A46 Newark Bypass

TR010065/7.38

7.38 Table of Errata

7.38 TABLE OF ERRATA

Viewpoint 18: View north-west from Newark Castle representative of views for visitors to the castle and gardens.

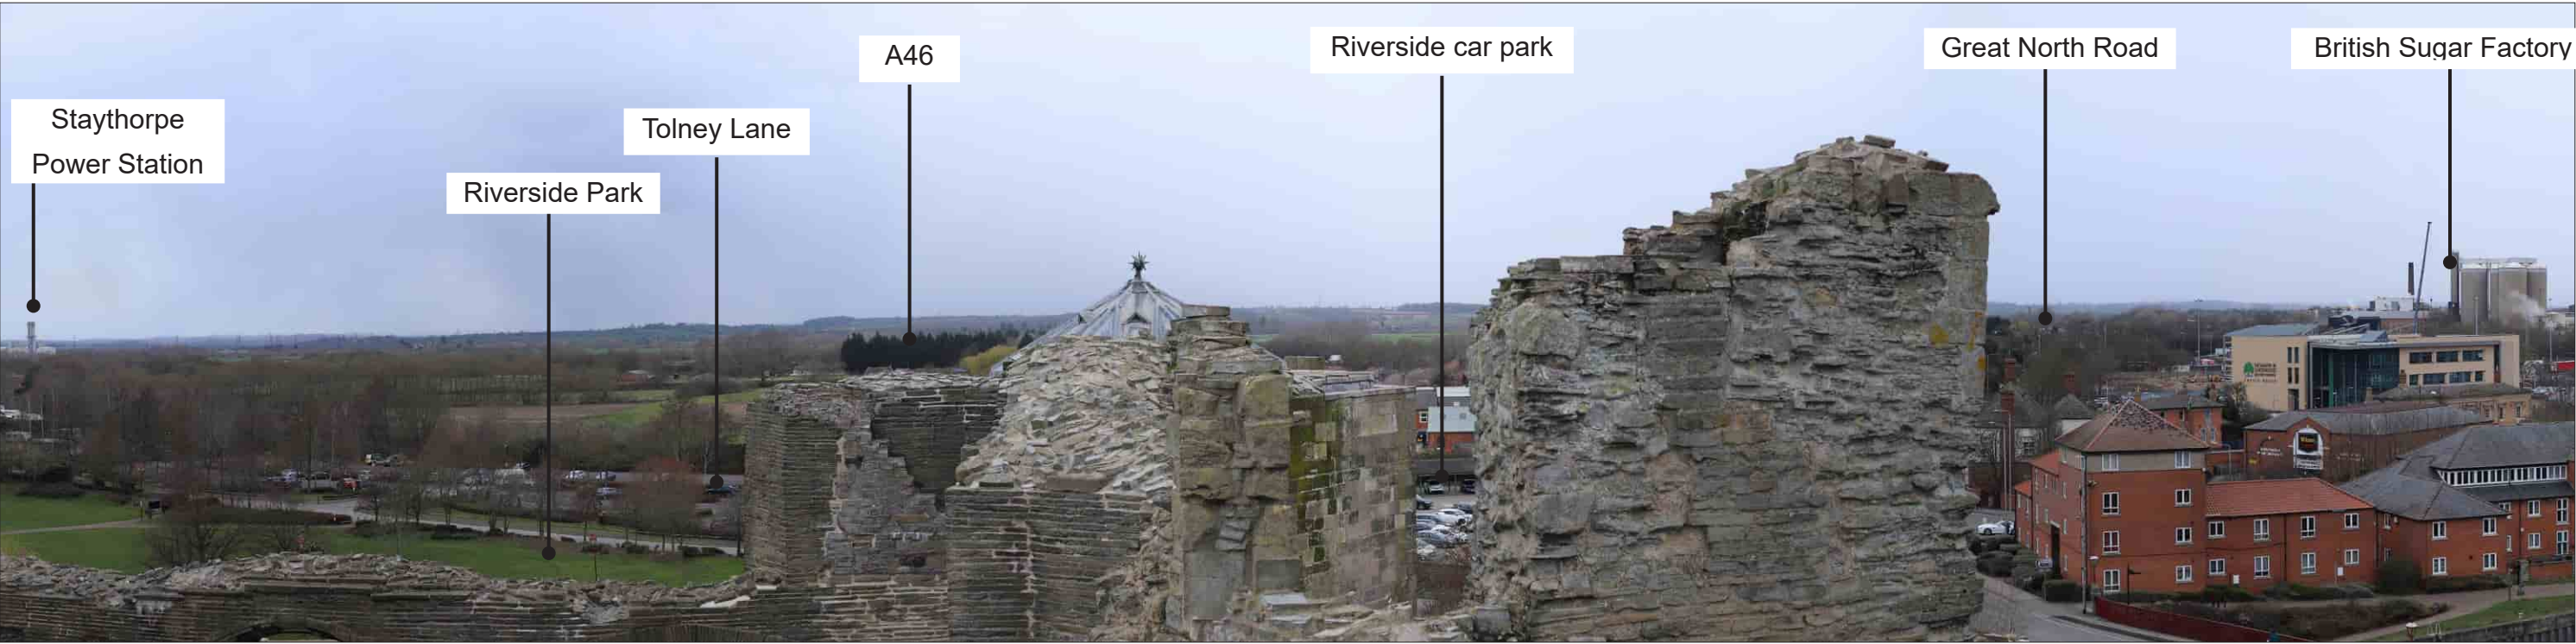
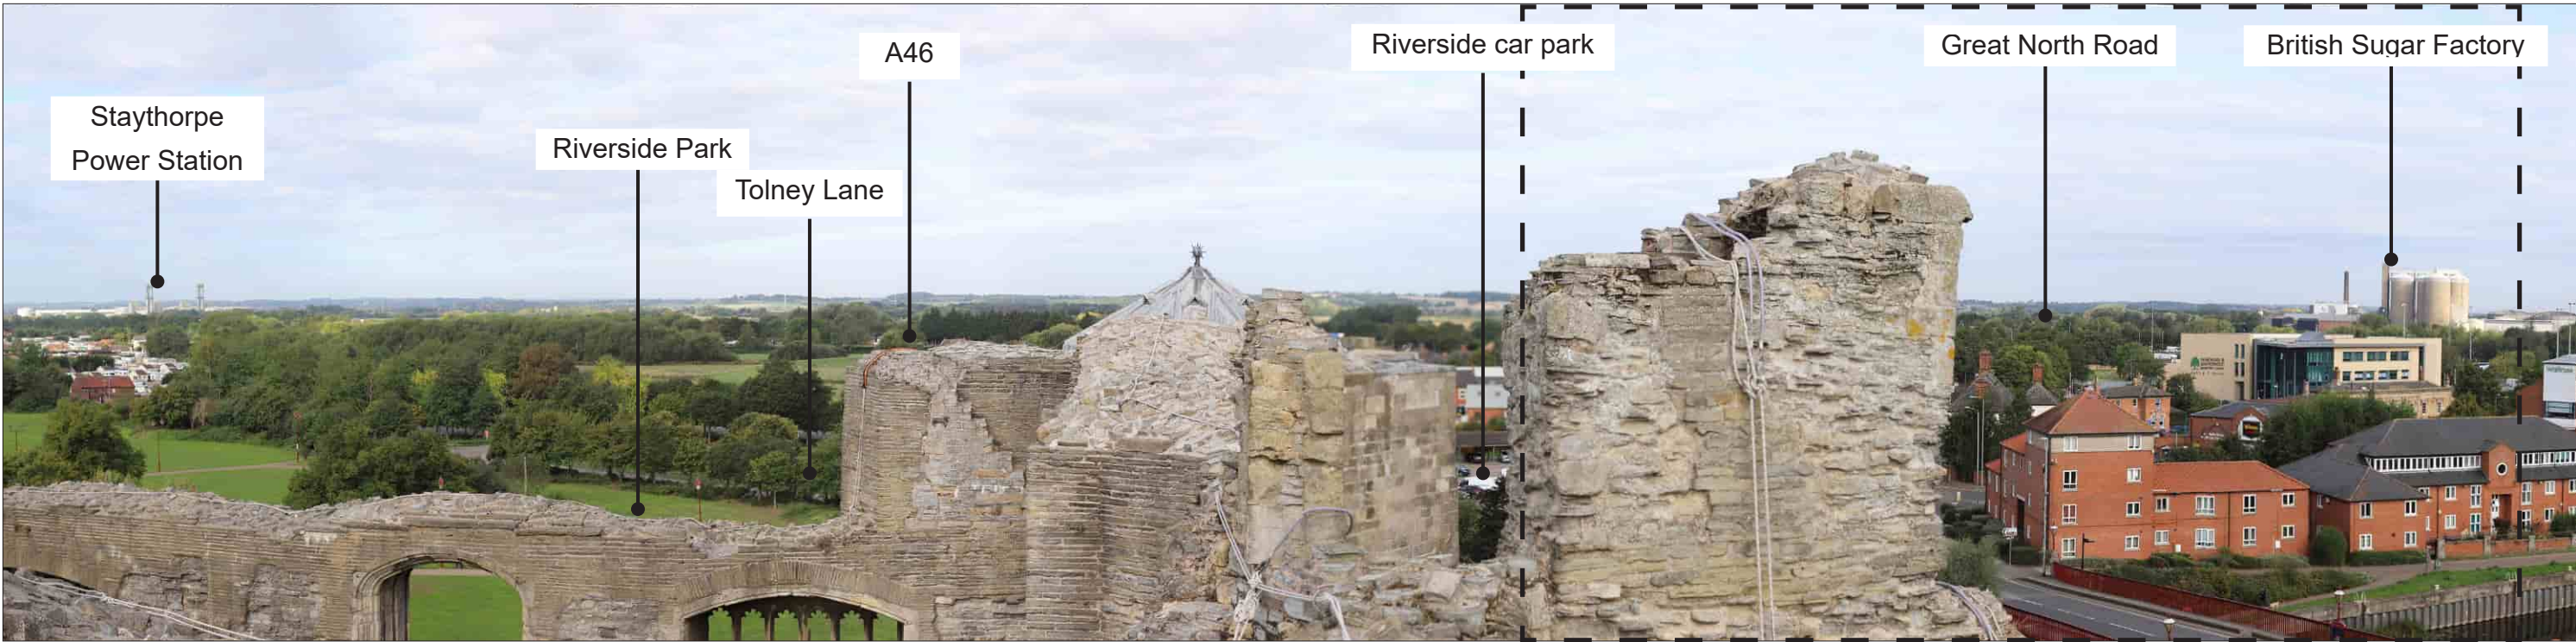
6.2.1	APP-138	Appendix 7.3 (Key Visual Receptor Photographs and Photomontages Part 1) of the Environmental Statement Appendices	16	Viewpoint 18: View north-west from Newark Castle representative of views for visitors to the castle and gardens	Identified by NSDC in RR-048	Spelling error	Applicant confirmed in response to relevant representations that the label on Viewpoint 18 should read “ Staythorpe Power Station ”, not “ Stanhope Power Station ”.
